# Bishopstone Parish Council

**S/23/1069 Demolition of existing chalet, erection of 1no. dwelling (Class C3), retention of garage and ancillary accommodation and associated works. At: The Chalet, Church Row Hinton Parva.**

Front Elevation

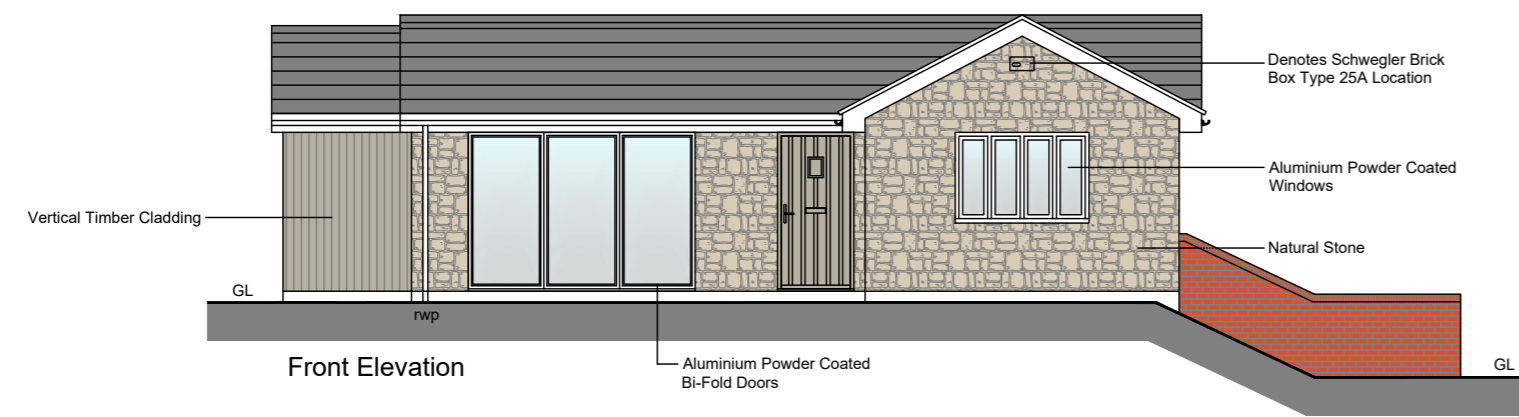
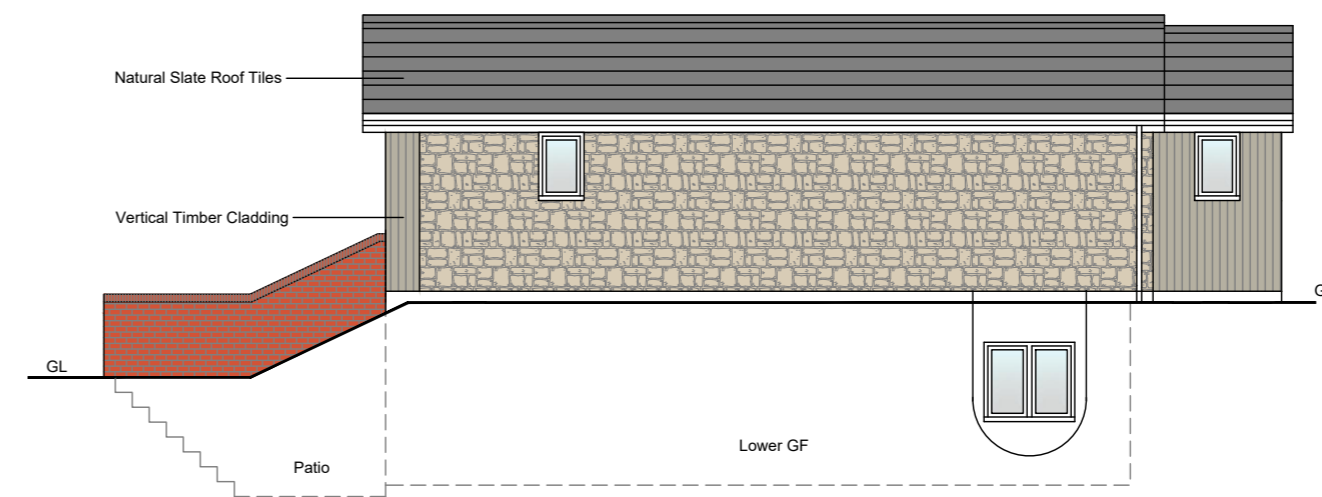
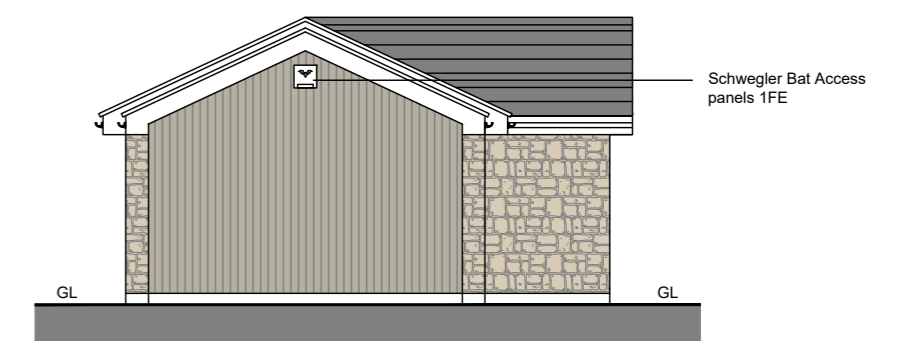
Bishopstone Parish Council has no objection to the dwelling in principle but is concerned about the increased footprint, the faux stone cladding being out of keeping and there being an excess of fenestration on the northern side.
